When we reviewed the “Moorebank Intermodal Precinct West – Stage 3 (SSD 10341), Traffic Assessment”, we were somewhat surprised with the expected performances of the intersections on Moorebank Avenue.

For now, we focus on the Moorebank Av – M5 intersection as shown in the Traffic Assessment.

Figure 2 Relevant page from M1CL EIS

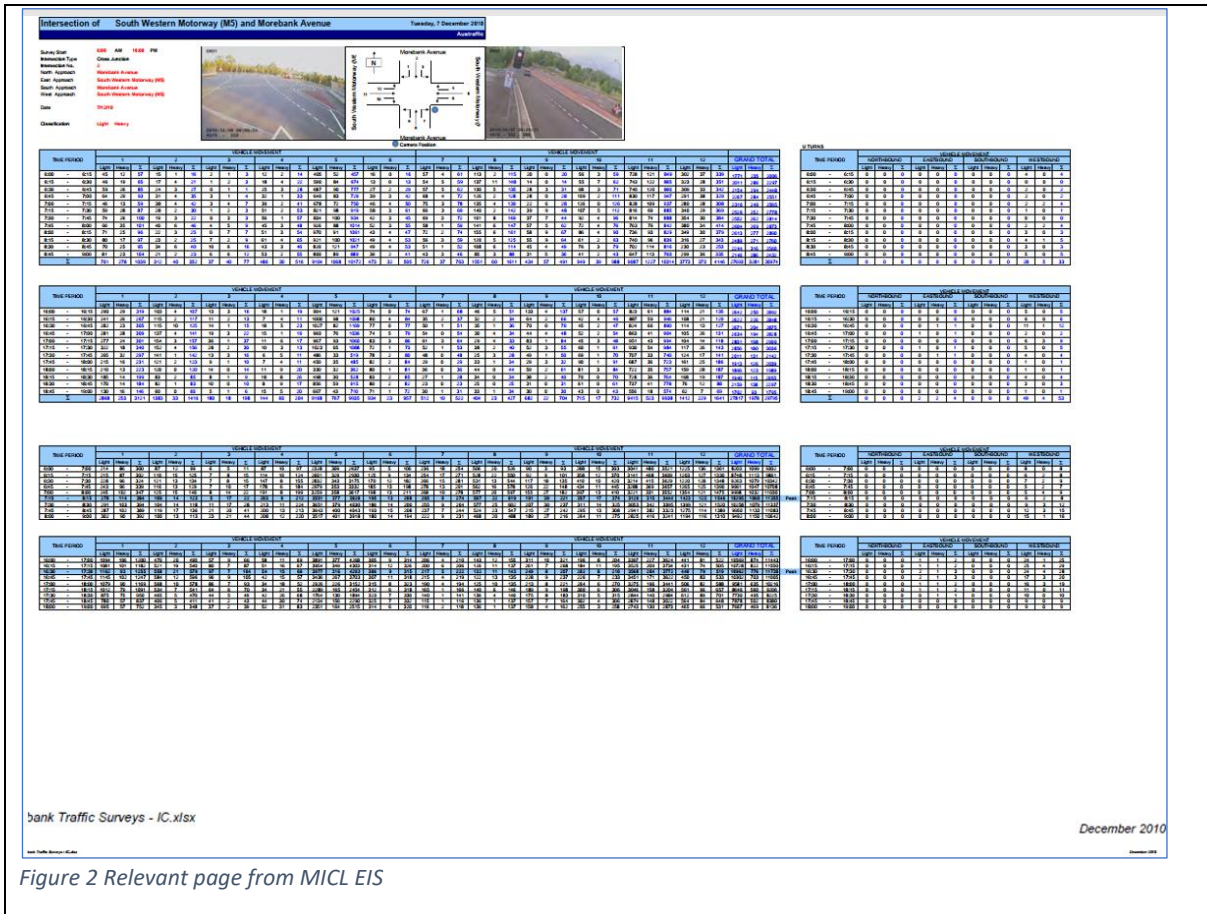
For reference we compared these flows to those that were surveyed on 07/12/2010 for the Moorebank Intermodal Company (MICAL), Environmental Impact Statement (EIS). For convenience, the page is reproduced in Figure 2.

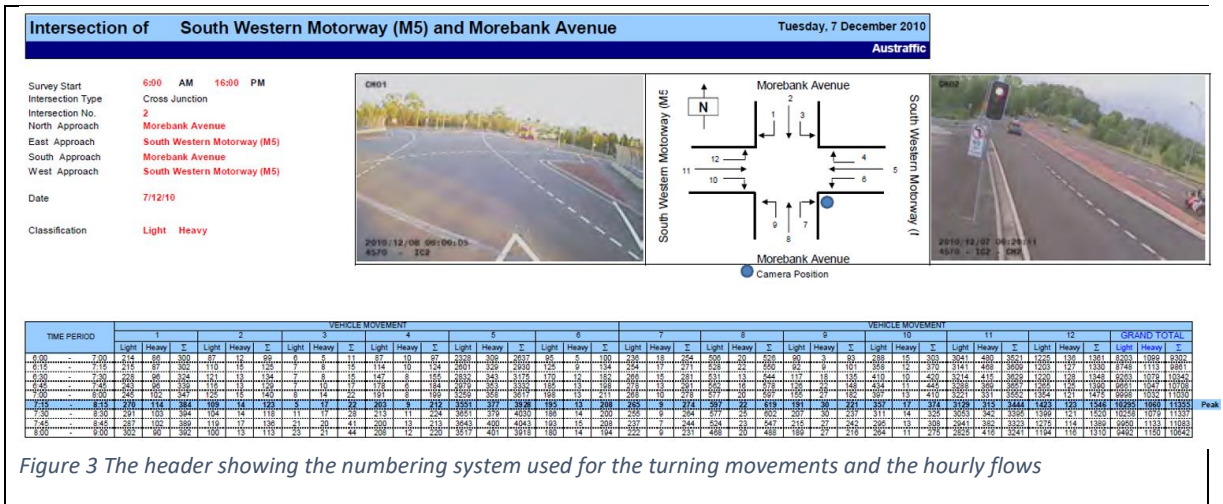
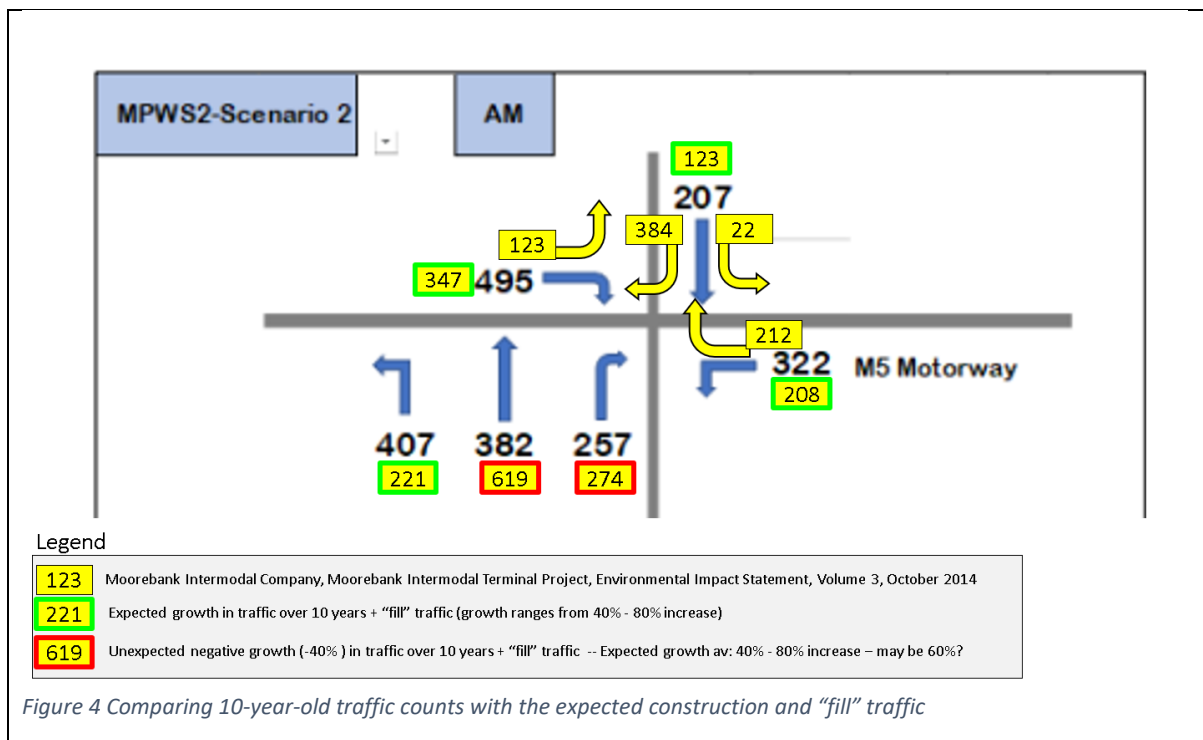
Figure 3 shows the numbers more clearly, and the page out of the EIS is not so legible. The table shows the AM hourly flows. The header shows the coding system for the numbers in the table.

For completeness, all the MICL, EIS flows are shown in yellow boxes, together with the movement arrows. All the yellow boxes show the 10-year-old MICL, EIS numbers.

The yellow boxes with green borders have numbers which are lower numbers than the Traffic Assessment numbers. This is fully expected. There is the 10-year growth in traffic, and the additional construction and "fill" traffic. The growth in traffic varies from 40% to 80%.

The yellow boxes with the red borders have numbers that are higher than the Traffic Assessment numbers.

In the northbound direction, the Traffic Assessment number is 237 vehicles per hour less than the 10-year-old EIS number, and 17 vehicles per hour less for the right-hand-turning movement.

The expected northbound traffic flow represents a **negative growth of 40% over the 10-year old surveyed flows**. Intuitively, the expected number of northbound traffic would consist of two parts: (1) add 40% to bring it to the surveyed flows 10 years ago, then (2) add the expected natural growth as well as the additional construction and "fill" traffic (for the other movements, that ranges from 40% to 80%). Based on this logic, in round figures, the expected northbound traffic should be about double the quoted figure.

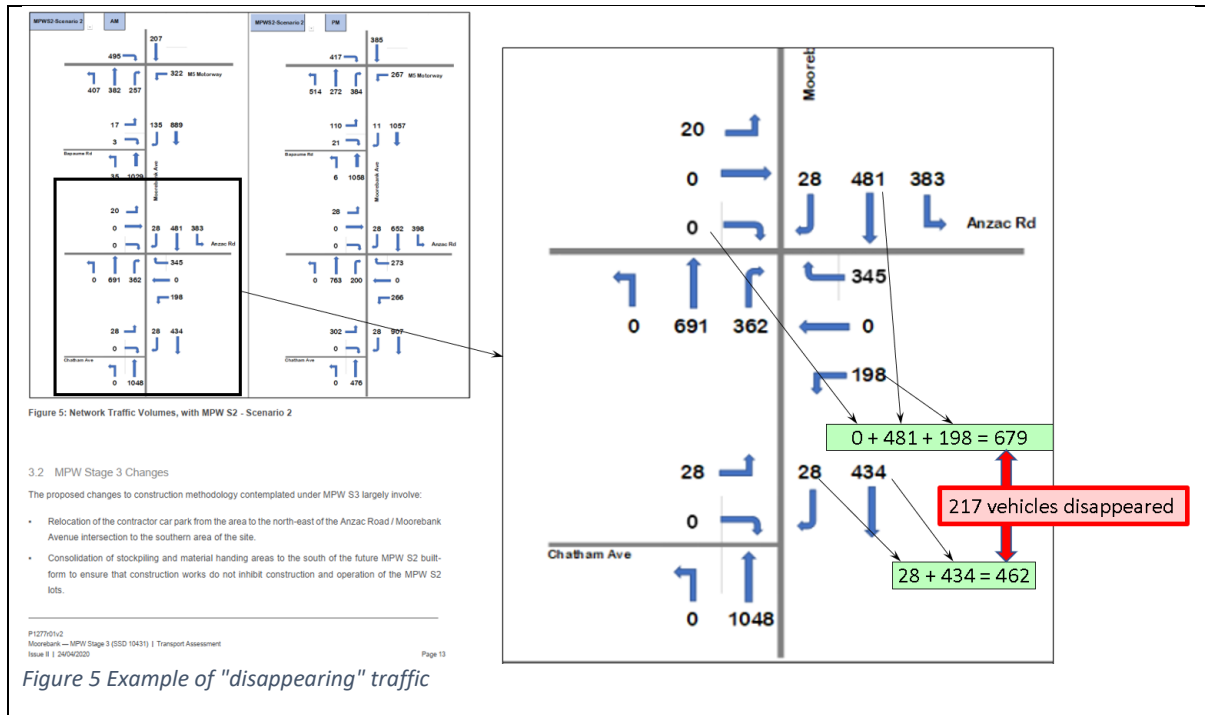
Figure 5 shows the calculation to estimate (1) all traffic travelling southbound, and (2) traffic arriving at the next intersection. In this example, 217 vehicles disappear between two very closely spaced intersections.

No explanation is given on the expected total (growth and additional Moorebank traffic) AM northbound traffic is only 40% of the 10-year old surveyed flow, nor the 217 disappearing vehicles. A simple exercise will show several other instances which do not make sense, or have explanatory notes.
